**Re: Sunward Ladera at 5760 St Joseph's Dr. NW
Erosion and Sediment Control Plan
Engineer's Stamp Date 6/12/25 (G11E067B)**

Based on the information in your submittal received 7/8/25, the ESC Plan can't be approved until the following comments are addressed.

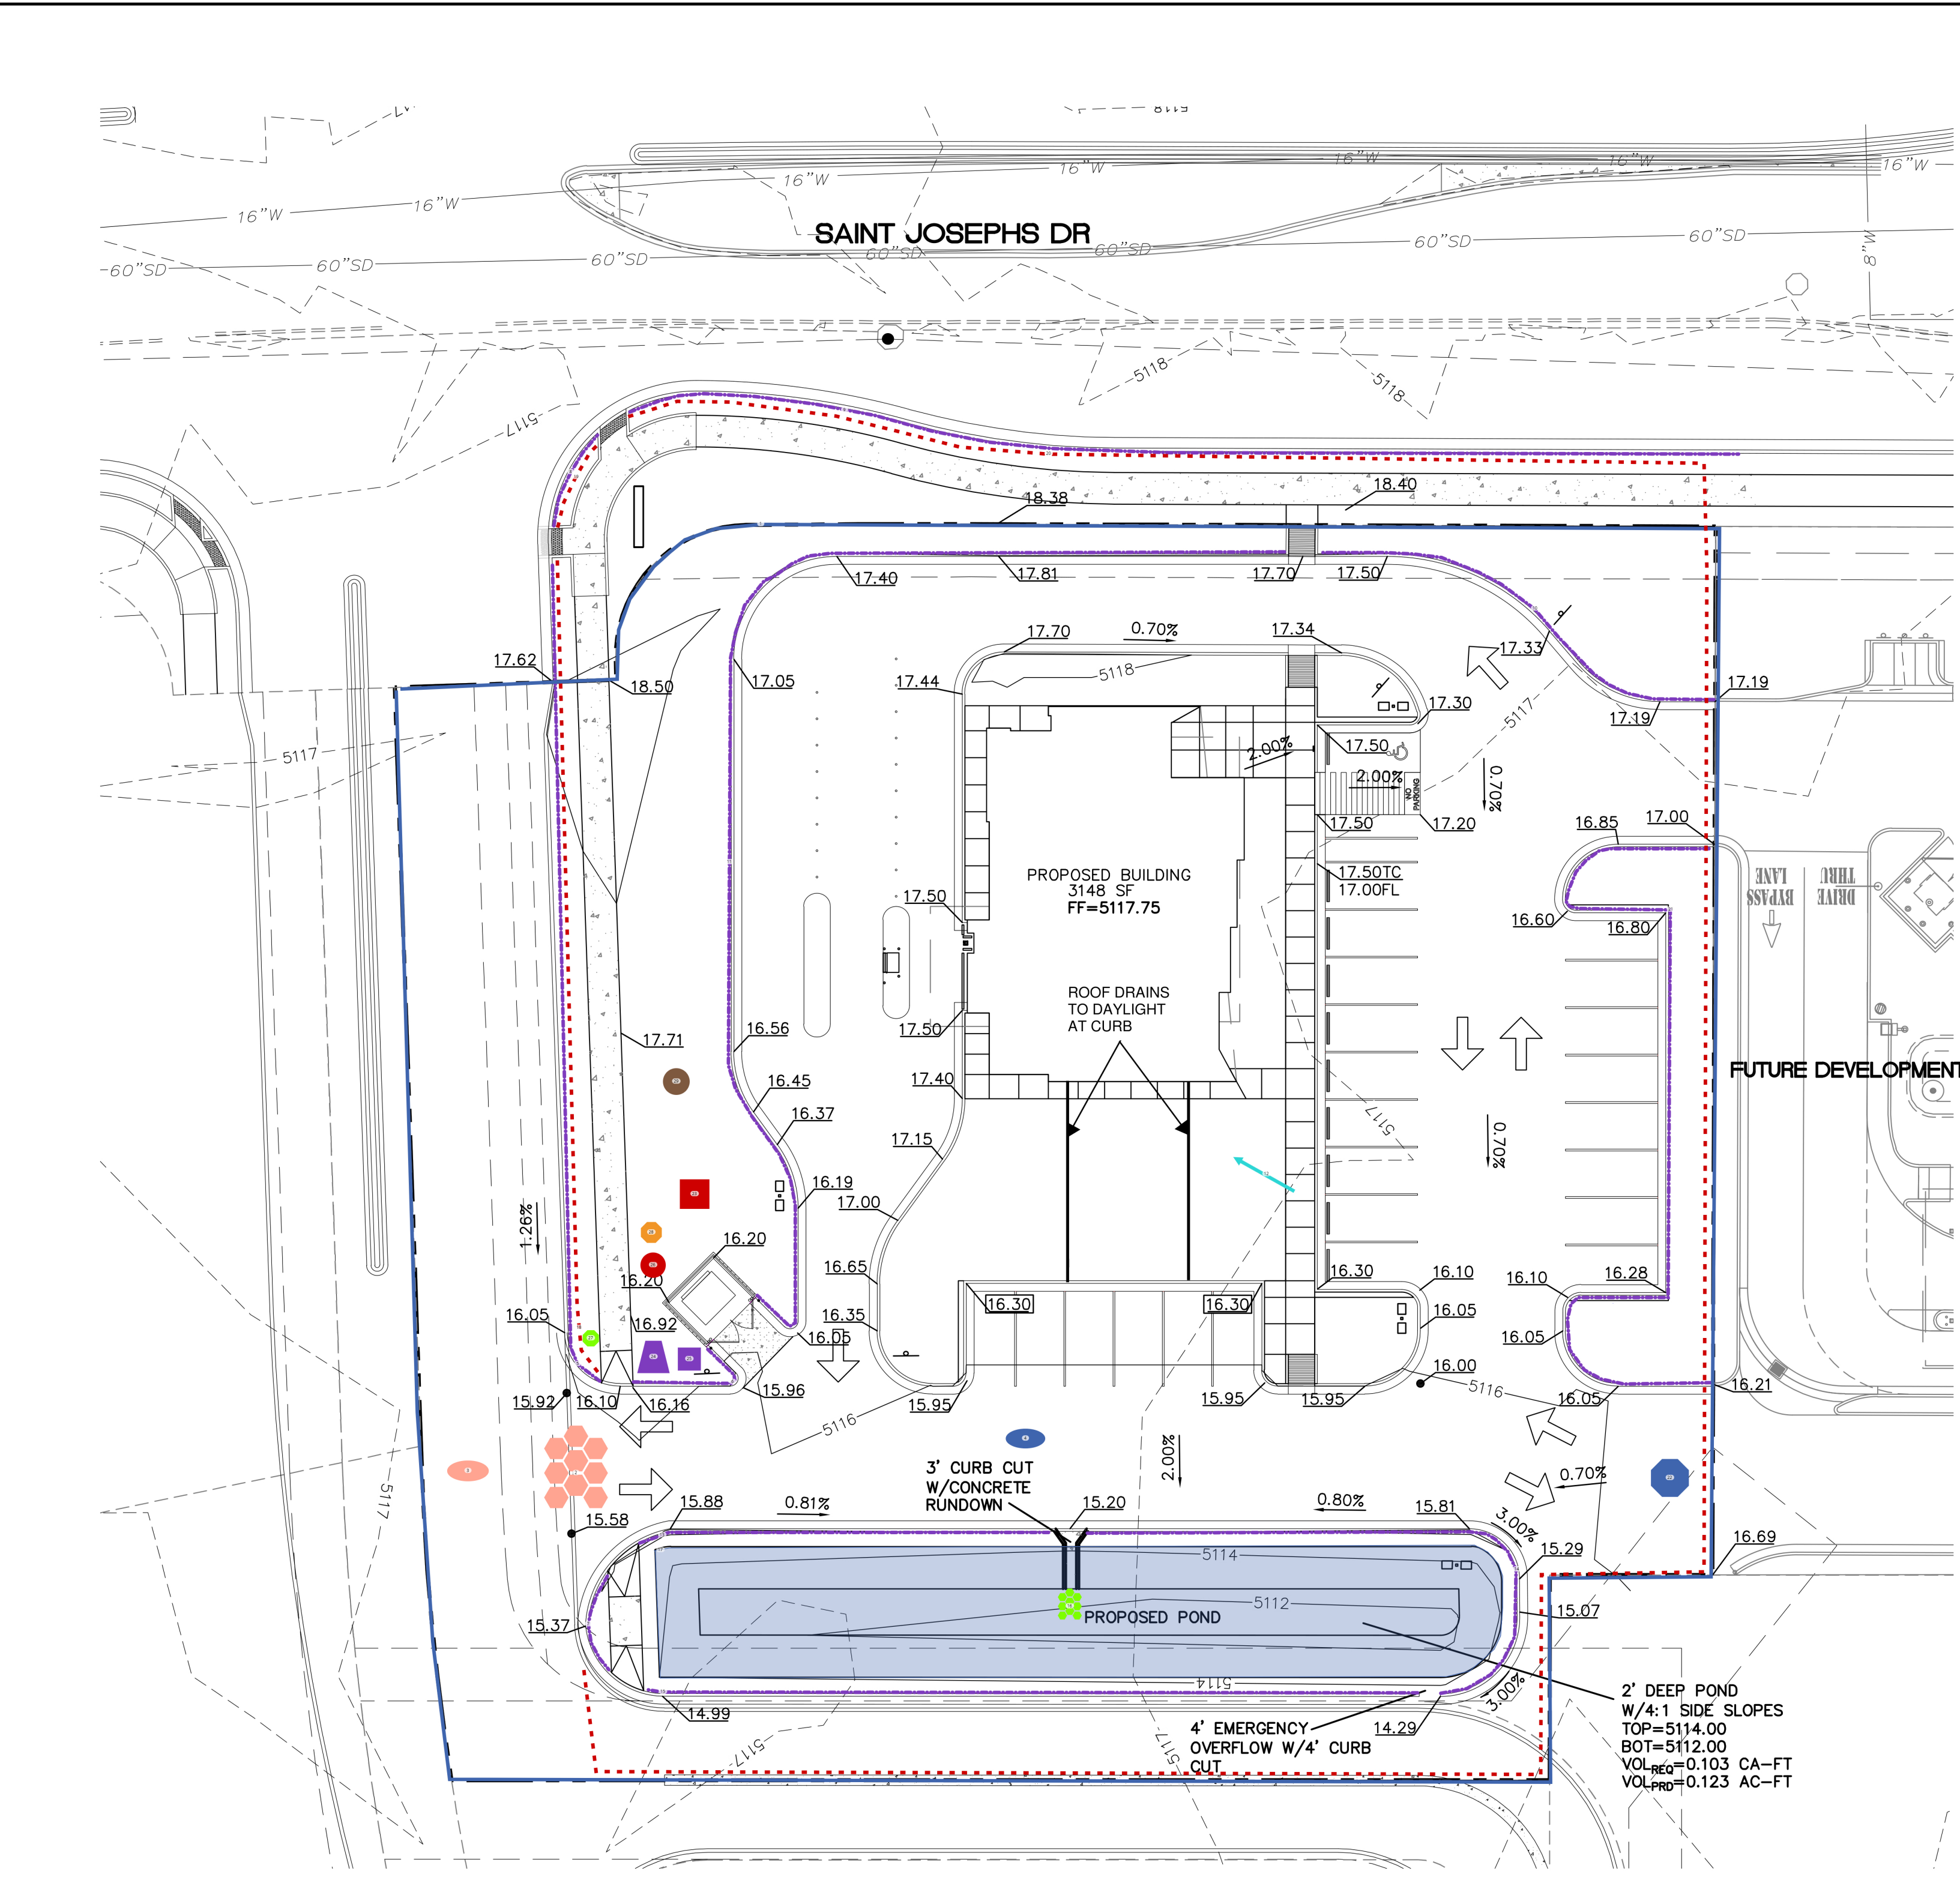
1. The NOI in your application was for Tierra Linda Apartments. The NOI with NPDES ID # NMR100658 is still in the name of Sandia Laboratory Federal Credit Union. The operator name, project name, and email addresses must be updated to the new corporate identity and included in a resubmittal to ABQ-PLAN.
2. The SWPPP must include site-specific interim and permanent stabilization per CGP 9.6.1.c.i. The Landscape Plan and Work Order sheets can be used to satisfy this requirement and should be submitted separate from the ESC Plan with the application to the Stormwater Quality Section of the Planning Department and they should be included in the SWPPP. Provide a specification on the ESC Plan for any disturbed areas not covered by the Landscape Plan
